Subject: Upgrades to John Palmer Public School (SSD-23330227)

Thank you for your email received 18 October 2021 requesting comments on the above proposal. Environment, Energy and Science Group (EES) has reviewed the relevant plans and information and provides the following comments.

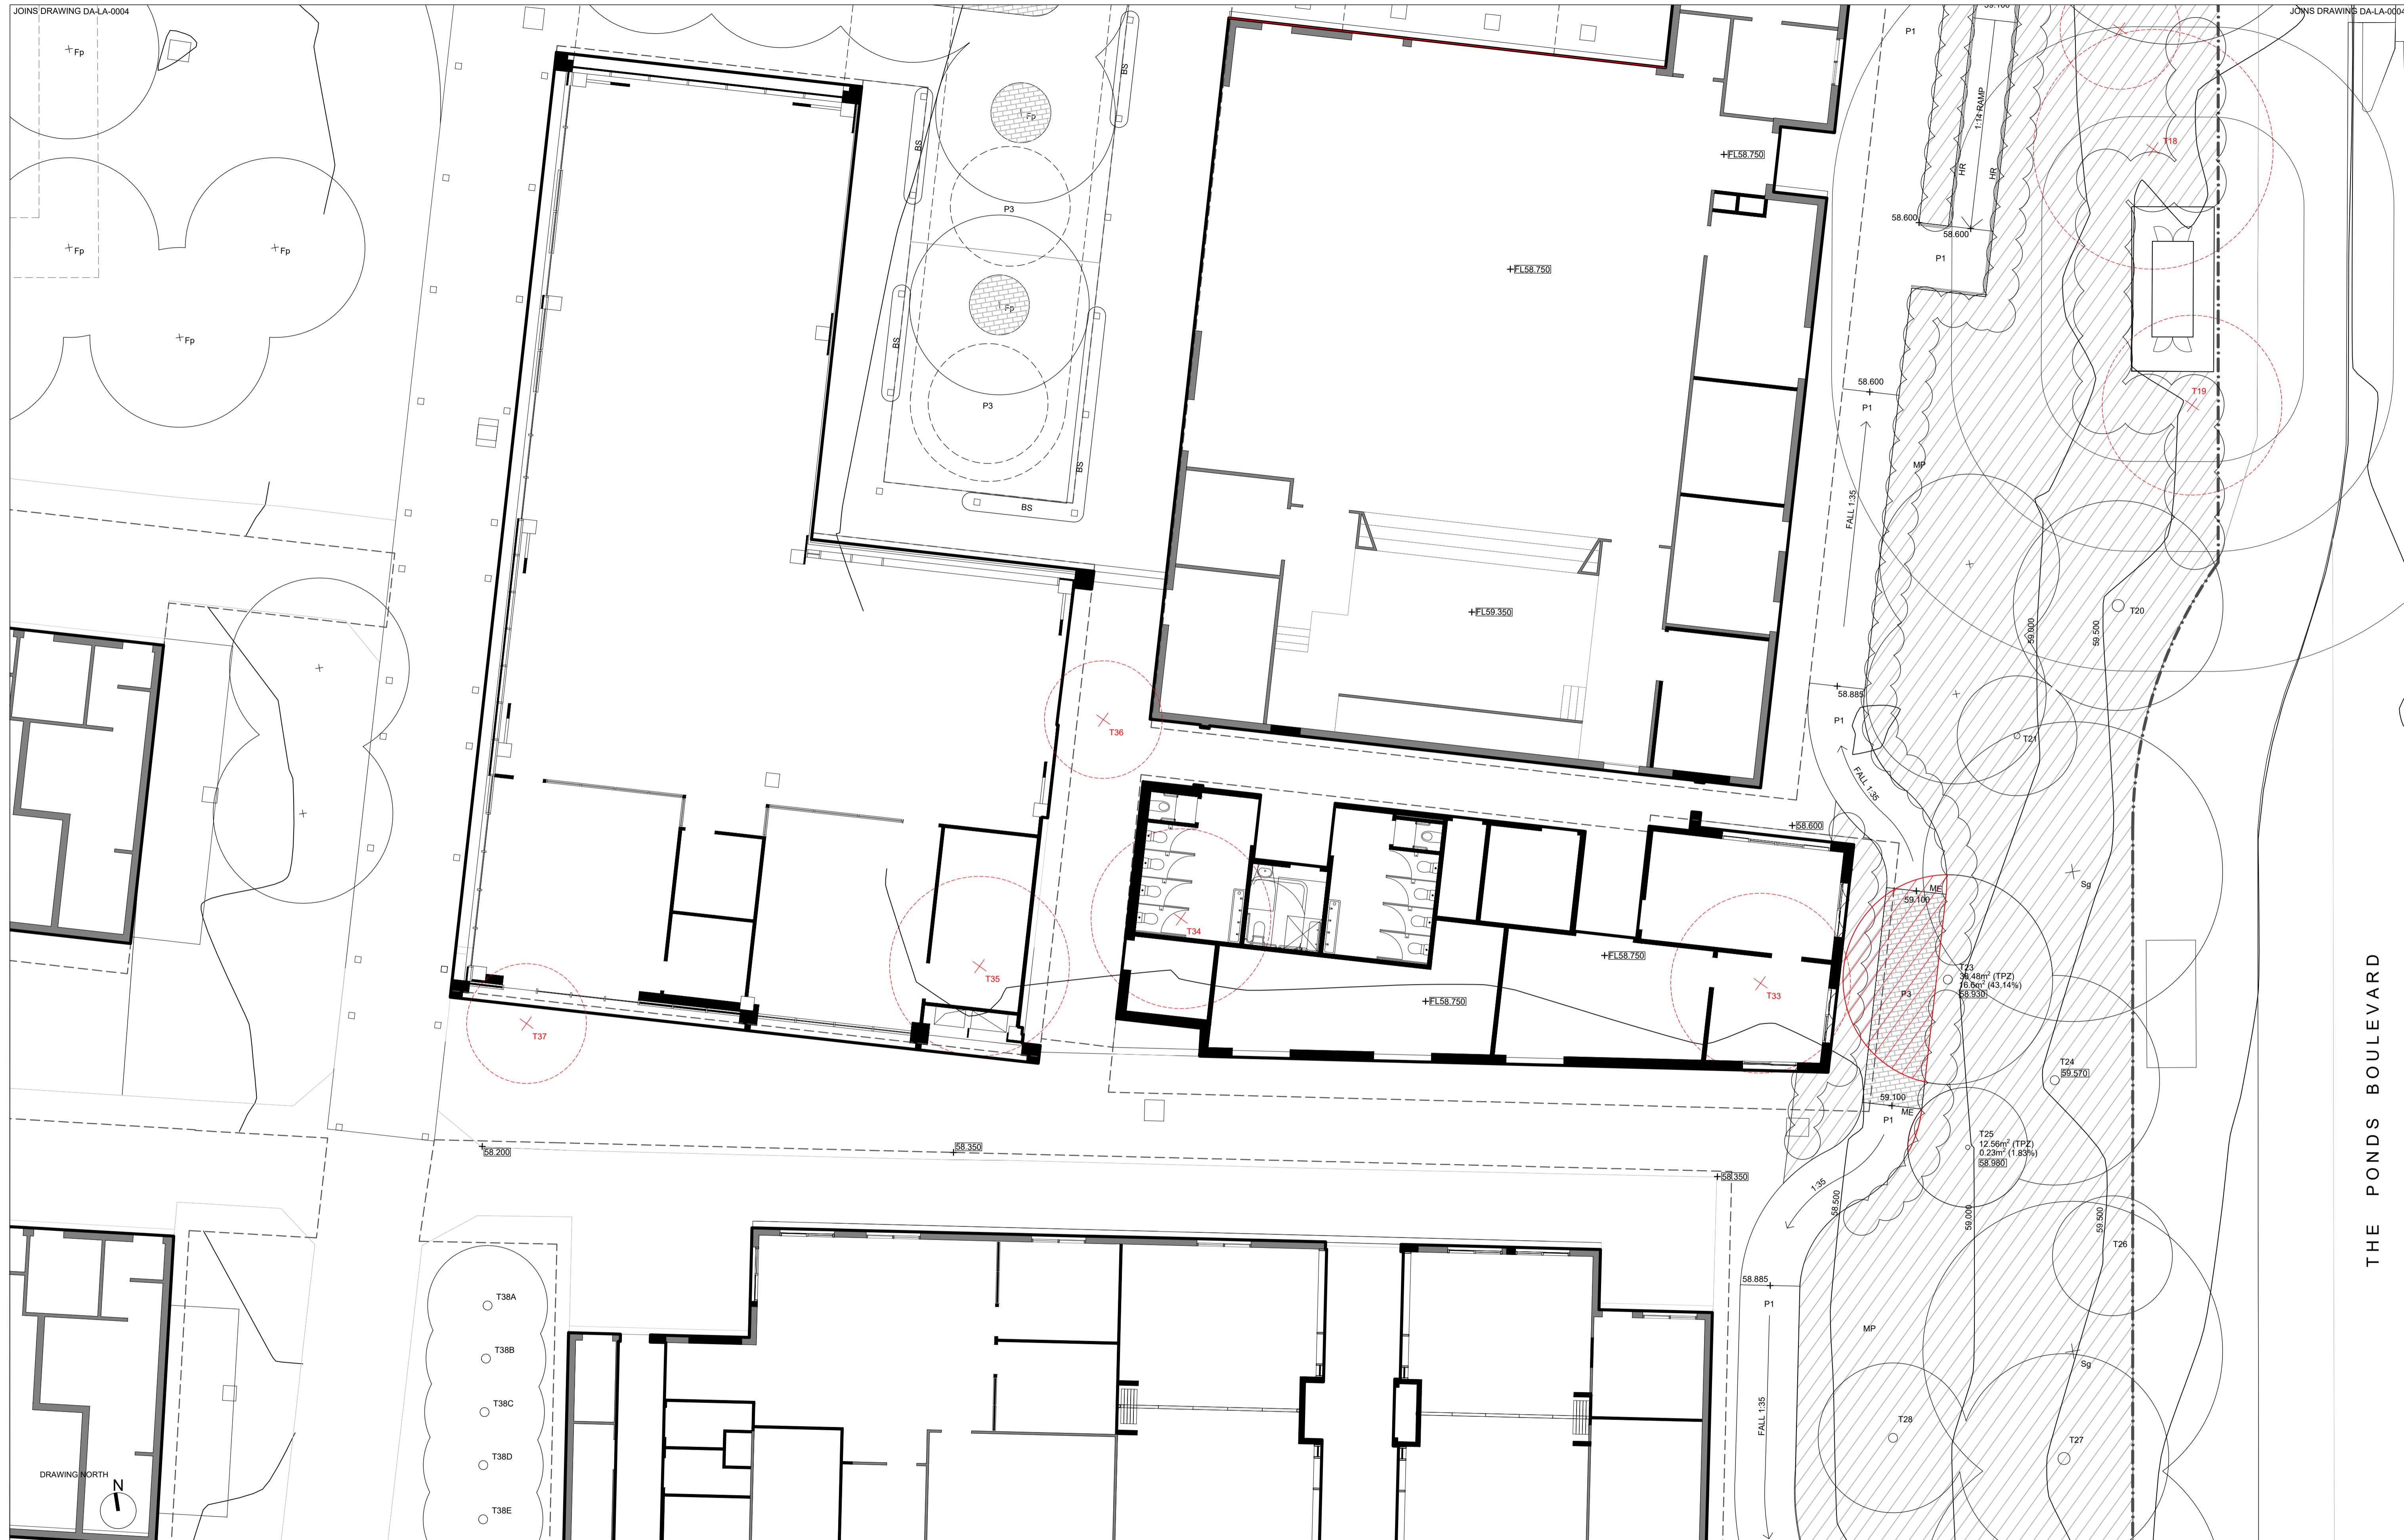
In relation to the impacts on trees, The EIS states '*The building has been setback approximately 8 metres from the northern property boundary and approximately 5 metres from The Ponds Boulevard to retain existing trees within these areas which are an established element in the landscape and provide screening*', however EES notes that trees numbered 1-5, 7-9,15 and 132 – 133 (as numbered in the Arboricultural Impact Assessment Report prepared by Eco Logical Australia) within The Ponds Boulevard setback are proposed for removal which is contrary to this statement.

Most of these trees have been allocated a medium retention value with fair to good health and structure. Importantly, the trees are semi mature and have established over the past 10-15 years to provide fauna habitat, landscape amenity and an increasing contribution towards mitigation of urban heat island effects on site. Given the relatively small Tree Protection Zone requirements of these trees, a minor increase to setbacks would allow their retention.
